# Preliminary and Final DRAINAGE PLAN AND REPORT

## **ROCKY TOP MOTEL AND CAMPGROUND**

June 14, 2019

County File No.: PPR2140

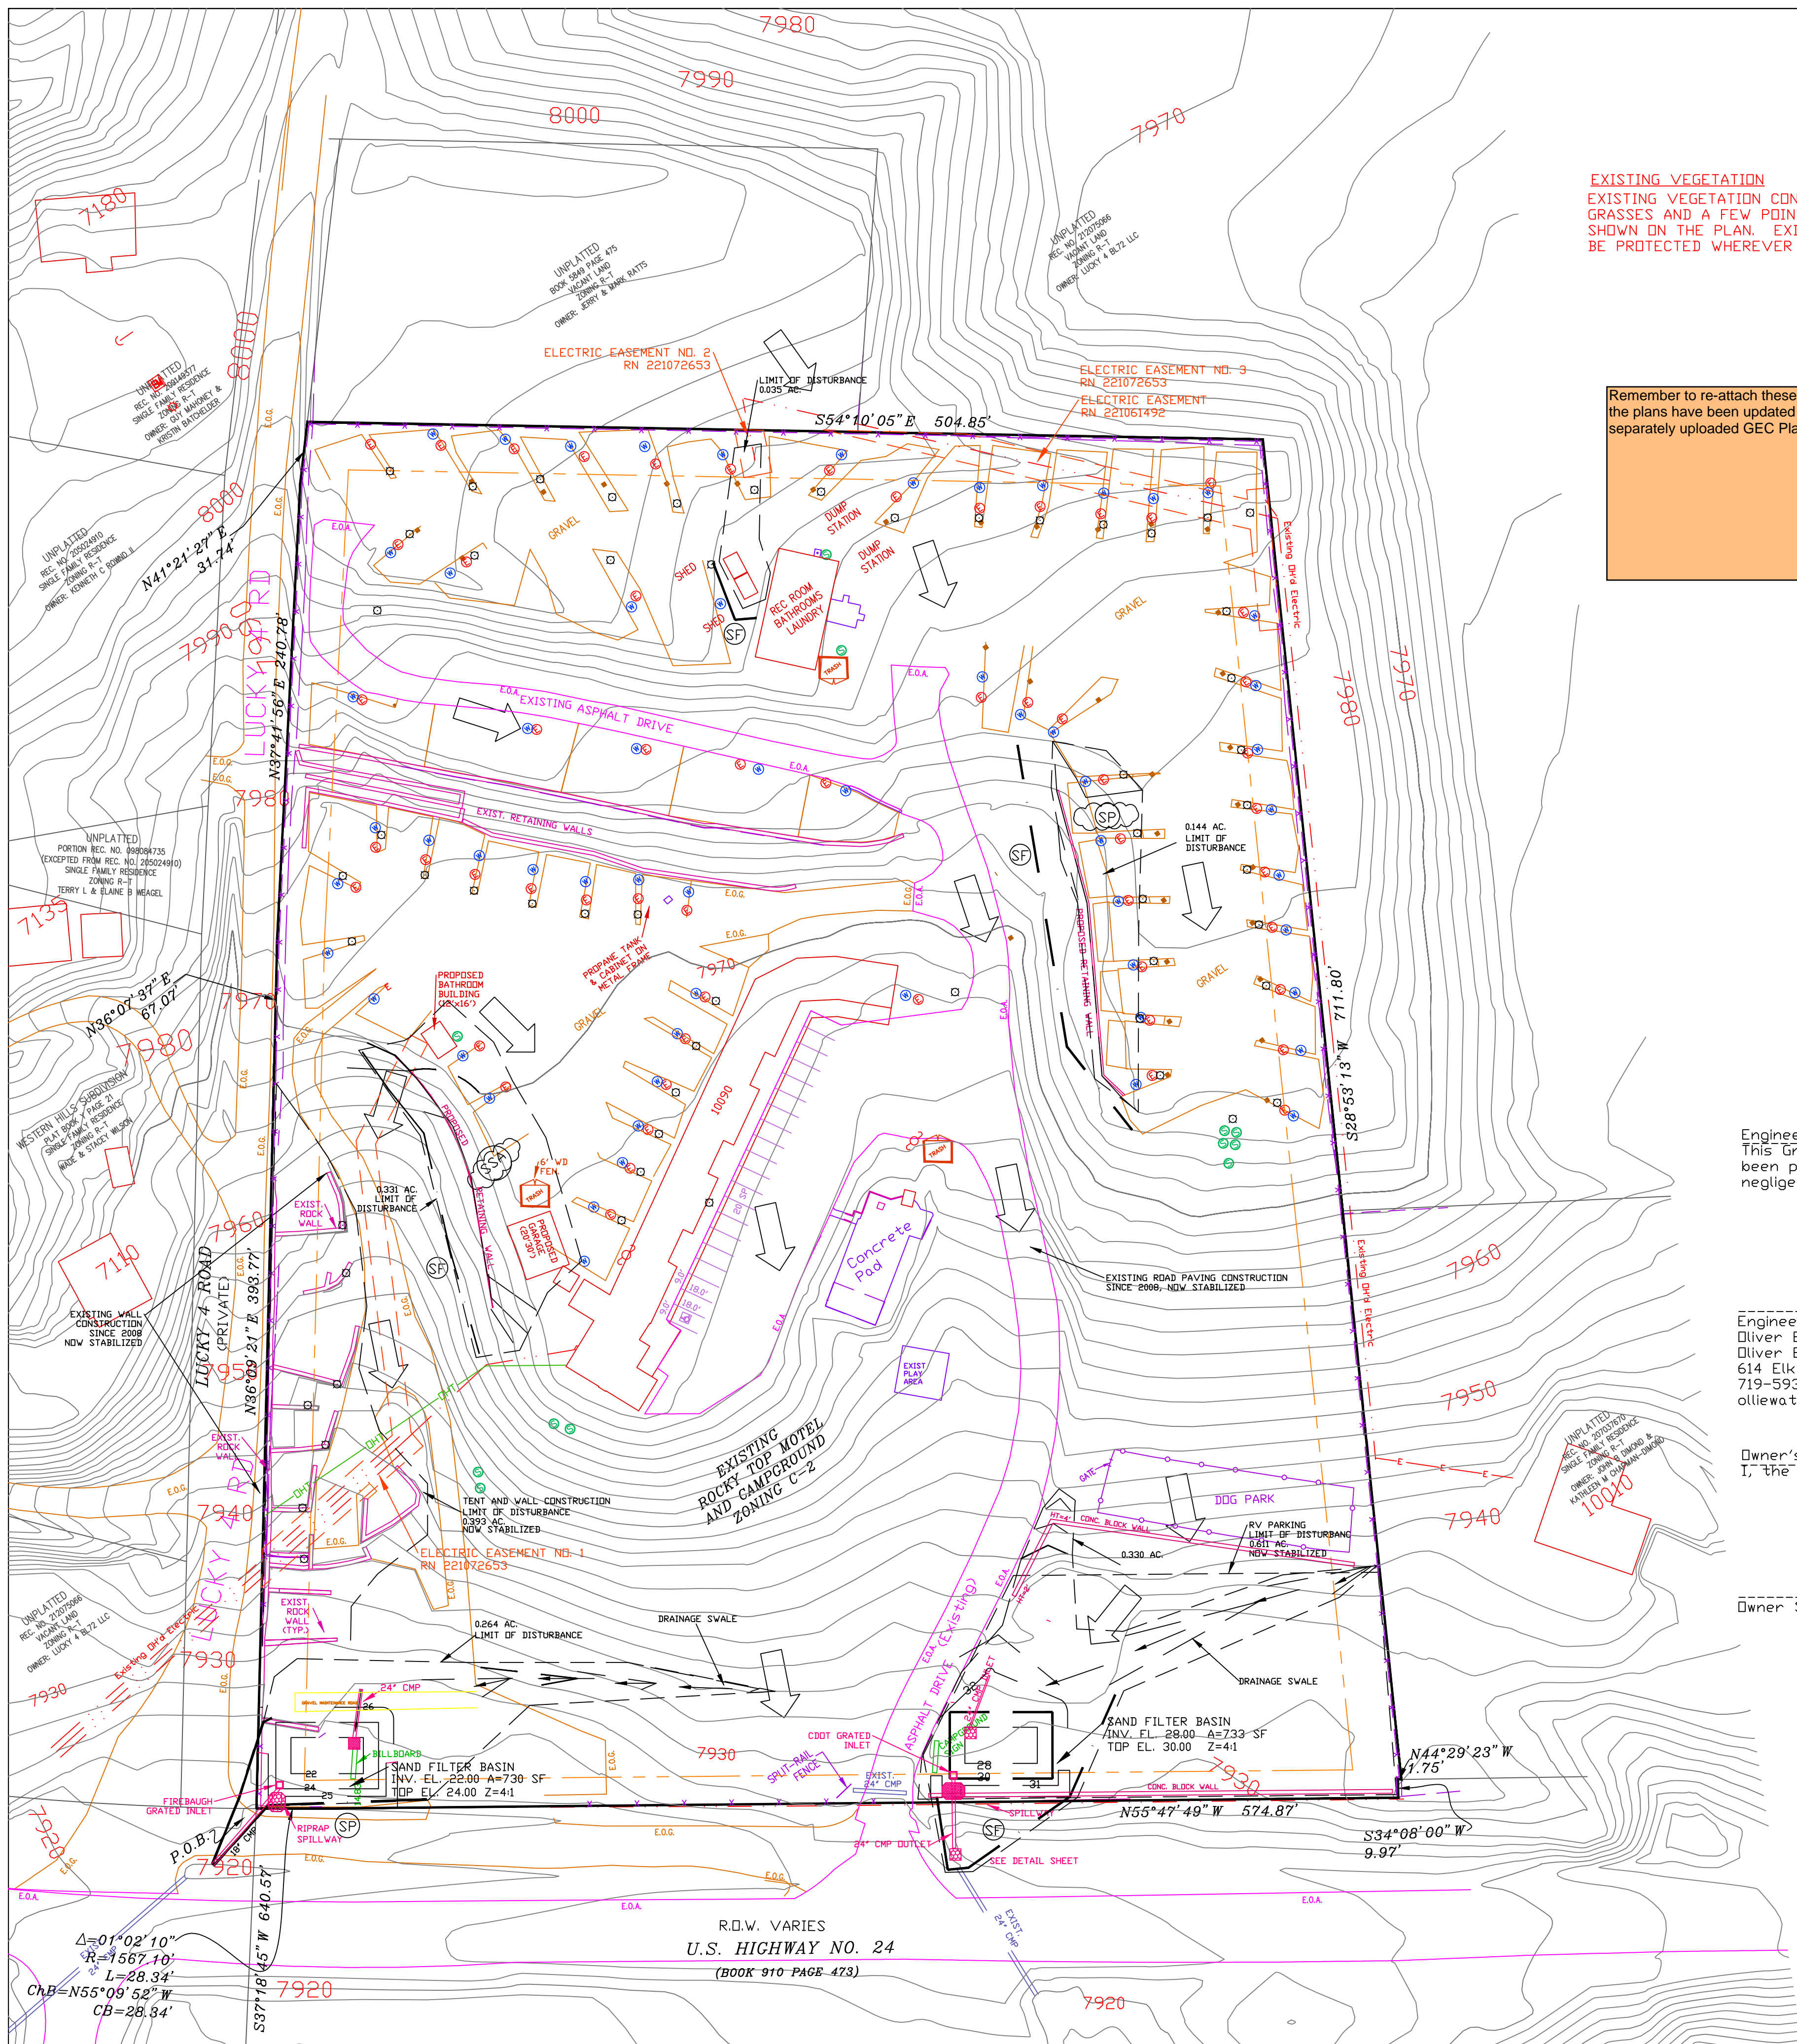
Review 1: Provide description of historic runoff, historic runoff values, and a historic conditions drainage map to compare with the proposed developed runoff values per DCMV1 chapter 4. Also, It was stated in the letter of intent for the variance of use that historic/undeveloped conditions would be addressed. See excerpt on next page

Review 2: Unresolved. Please provide analysis of the historic conditions as stated above. As part of your historic conditions analysis please describe the conditions on the west side of the development prior to retaining walls on the property line and tent campsites being installed. Also, the main driveway should be analyzed as dirt/gravel in the historic conditions. Additionally, the letter of intent indicates that cement pads will be added at these campsites. These should be accounted for in your developed conditions runoff. The developed conditions runoff should be compared to the historic conditions runoff.

The total of the 4 areas of disturbance shown on the GEC Plan is actually 0.695. Revise.
